DRB Application No.: **03-01460 (P&F)**

Project # **1002531**

Project Name: **CIELO SU TIERRA SUBD.**

DEVELOPMENT REVIEW BOARD--SPEED MEMO

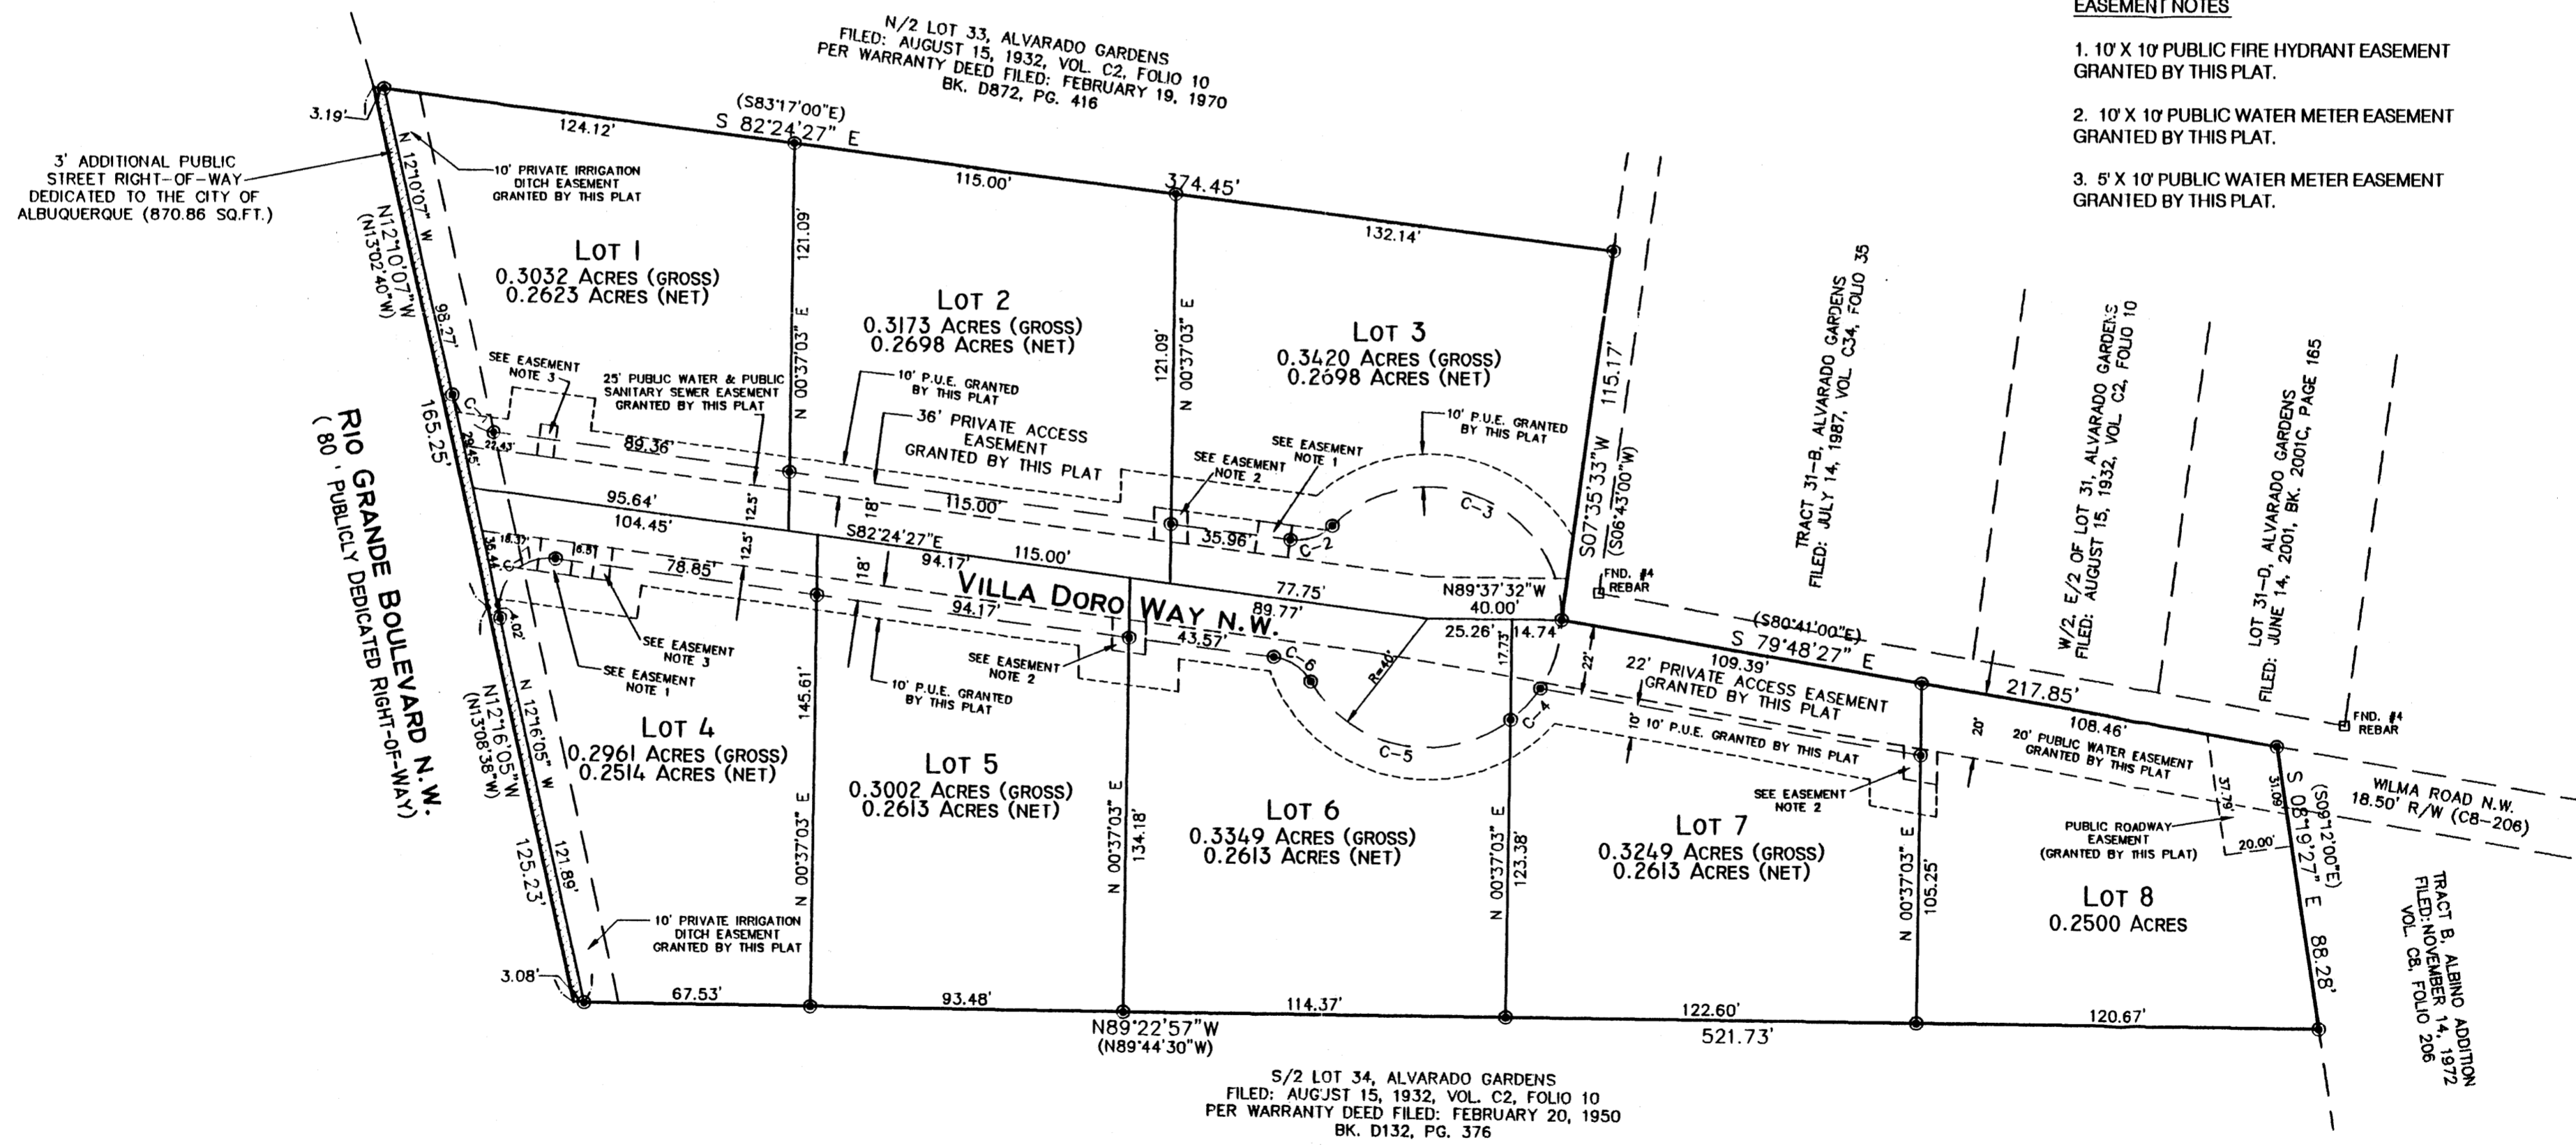
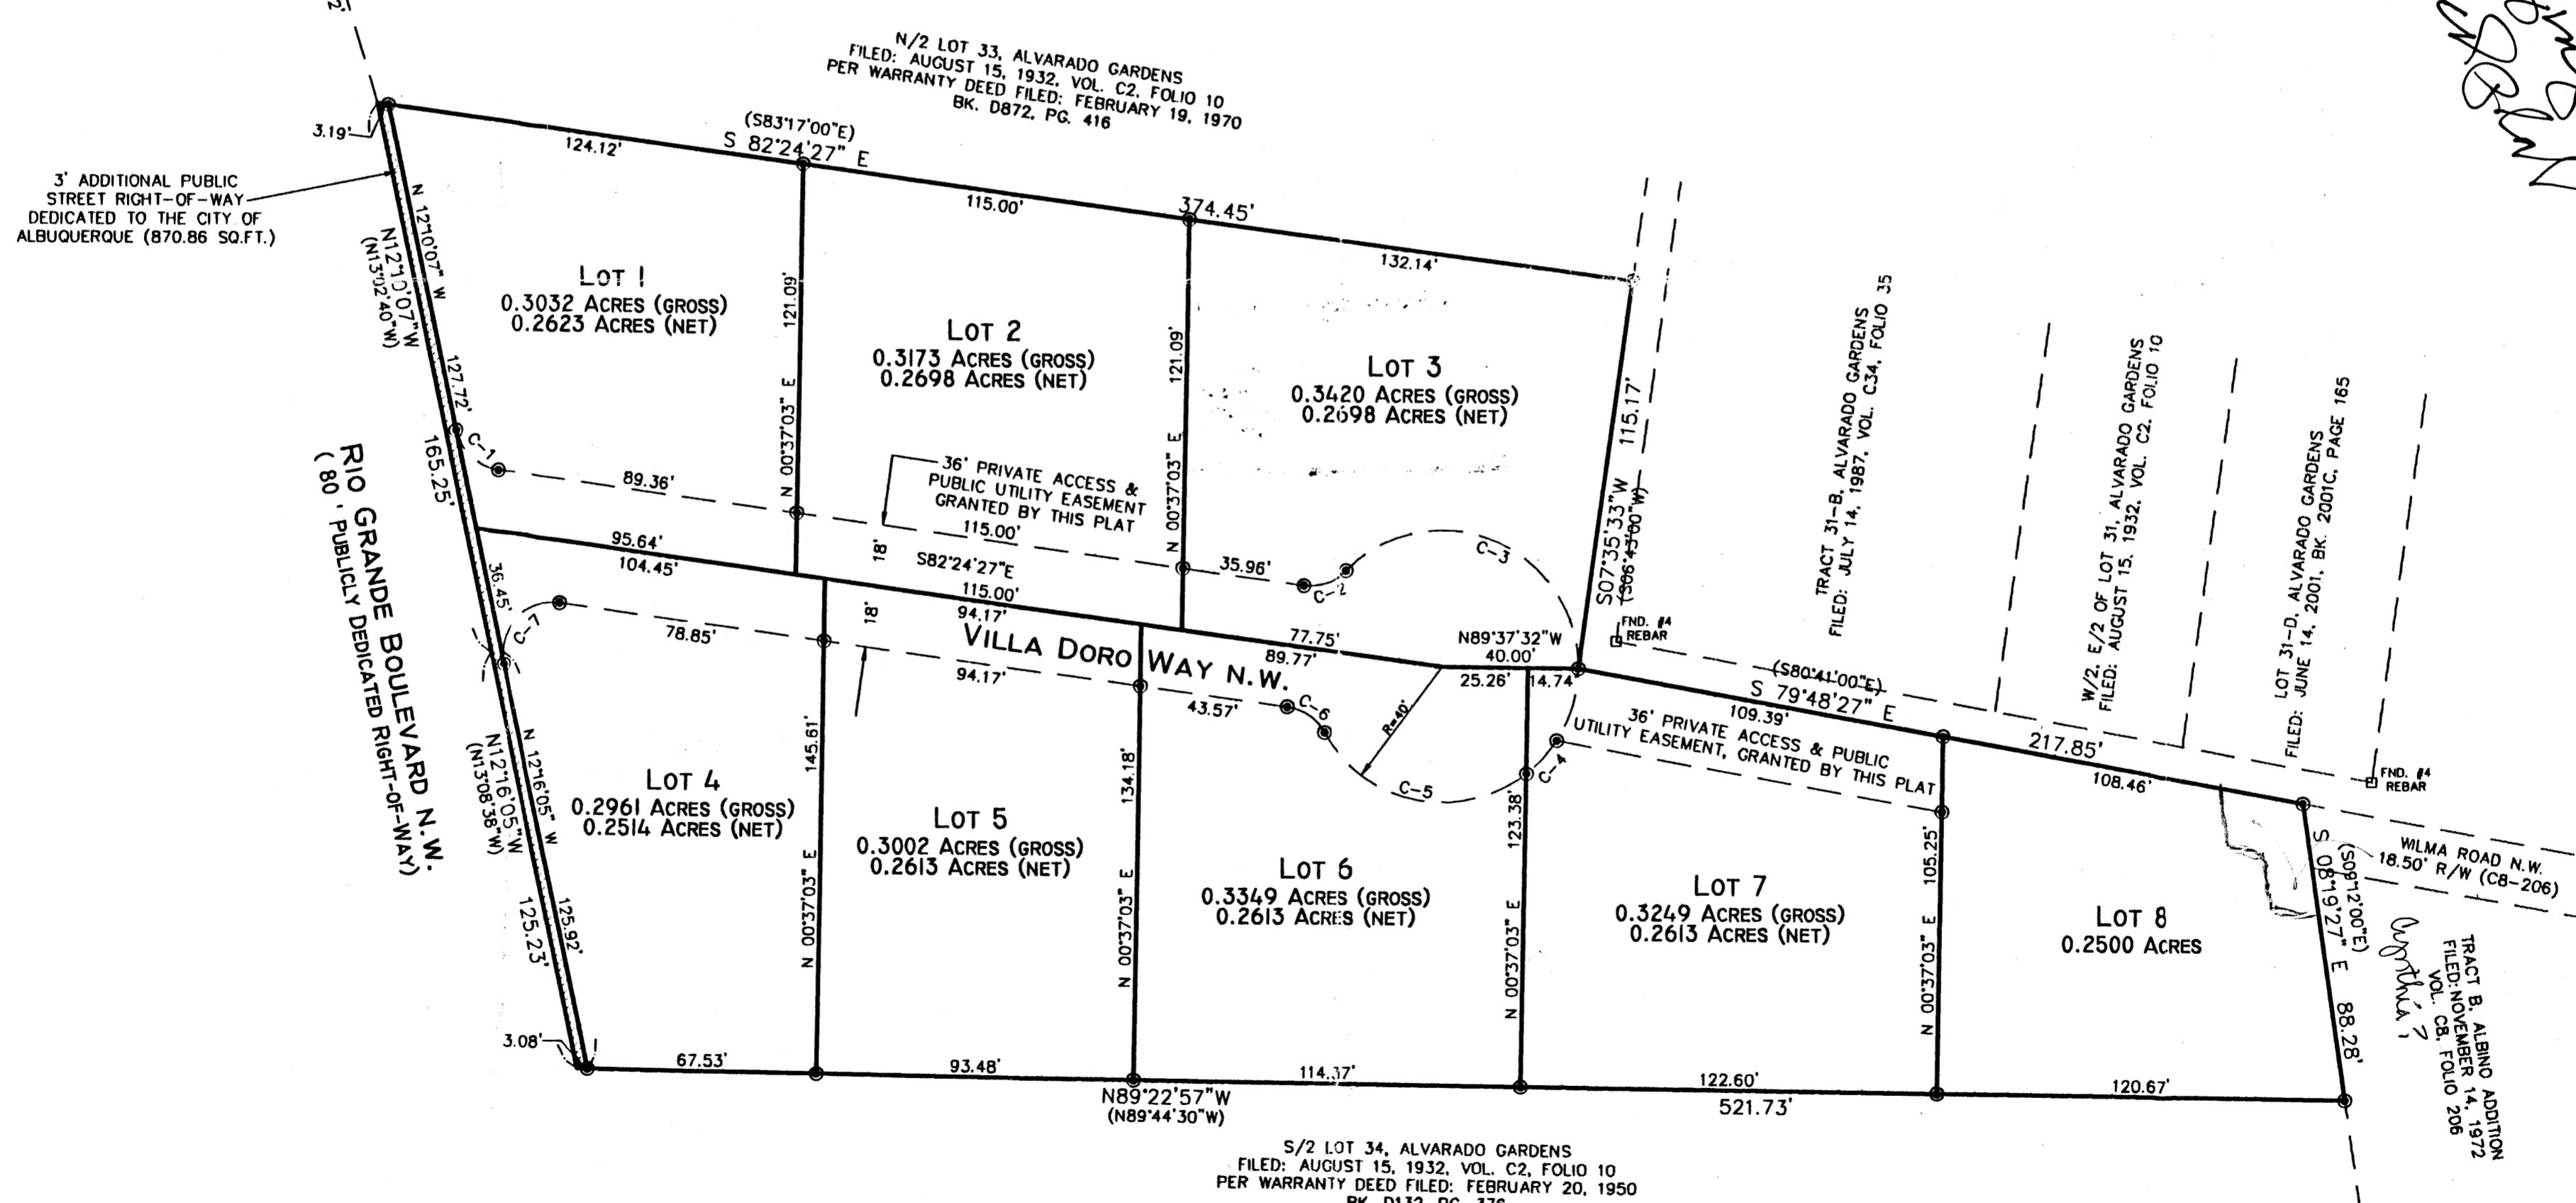
☒ TRANSPORTATION: HAUL ROADS TO BE MOVED TO NOT
IMPED ACCESS 1 (1/2 MILE SW)
AS-DAYS Wet
4-12-04

☒ TRANSPORTATION: HAUL ROADS TO BE MOVED TO LOT
IMPEDE ACCESS

1. Wilma Street will need to meet the satisfaction of the Traffic Engineer on the final plat.
2. A turnaround or other appropriate dedication may be required.
